**Town & Country Planning Act 1990 (as amended)
Town and Country Planning (Development Management Procedure) (England) Order 2010 (as amended)
Application for Planning Permission**

Development Erection of a 3 Storey Building to Create 3 x 1 Bedroom Flats

Location 1 Willow Brook Wick Littlehampton

Existing and Proposed Side Elevations.

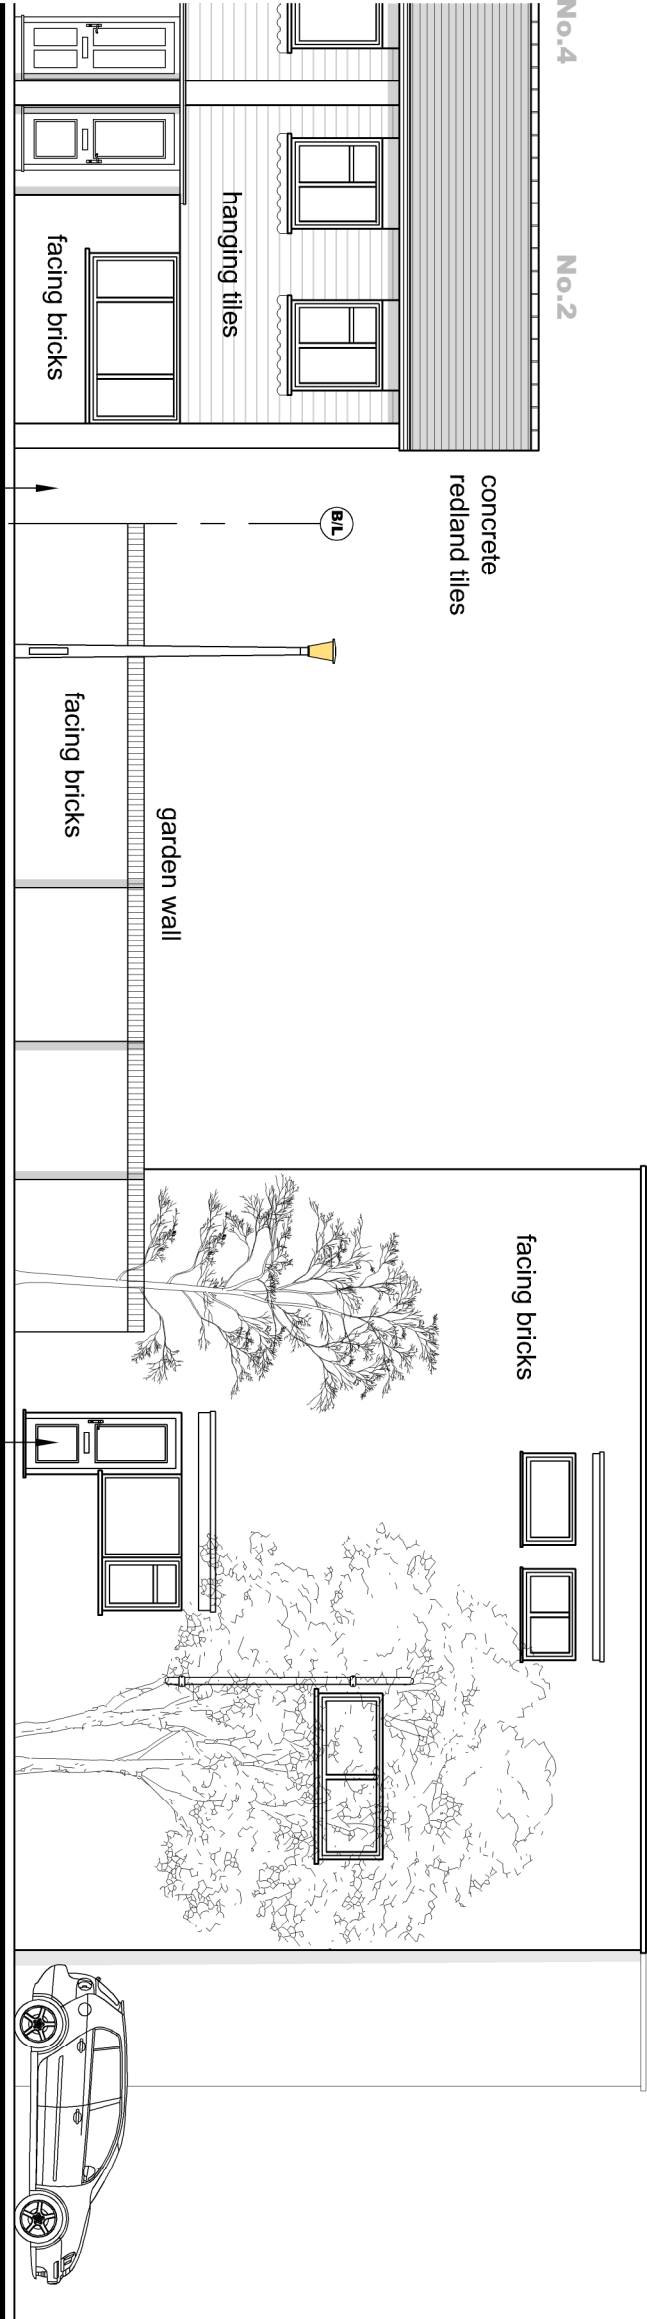
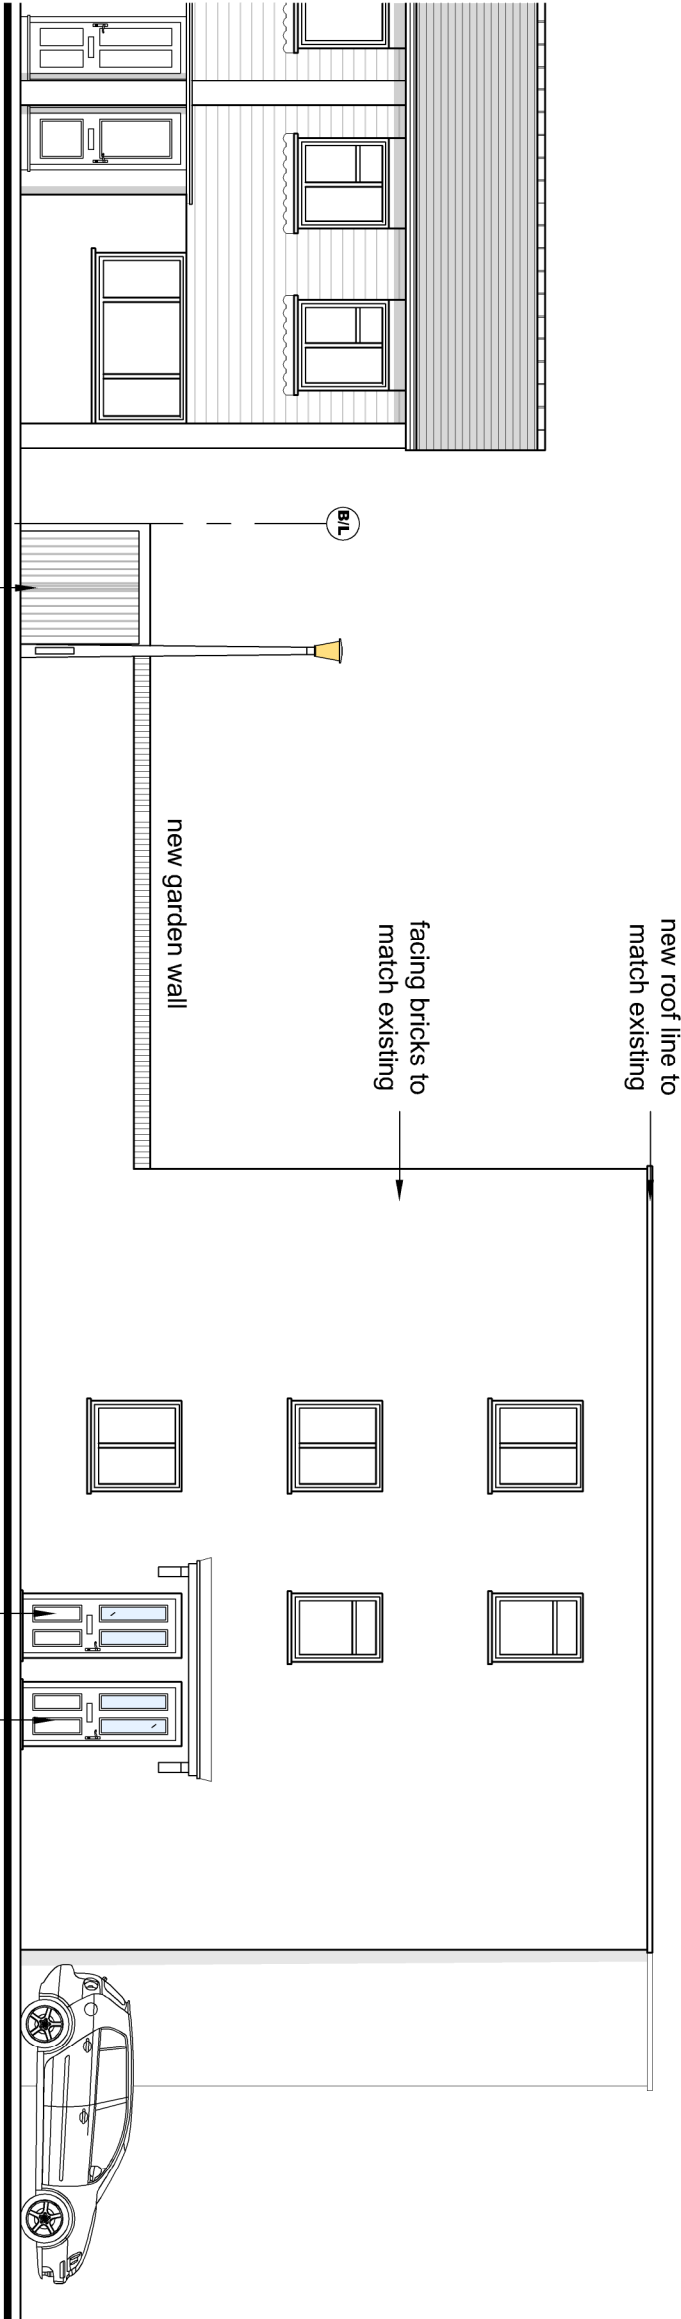
Please submit 1 electronic or 3 paper copies of revised existing and proposed side elevations in accordance with the guidance notes available on our website detailed below (click on National List). The submitted side floor plans and elevations do not accord, there appears to be windows missing from the ground, first and second floor plans.
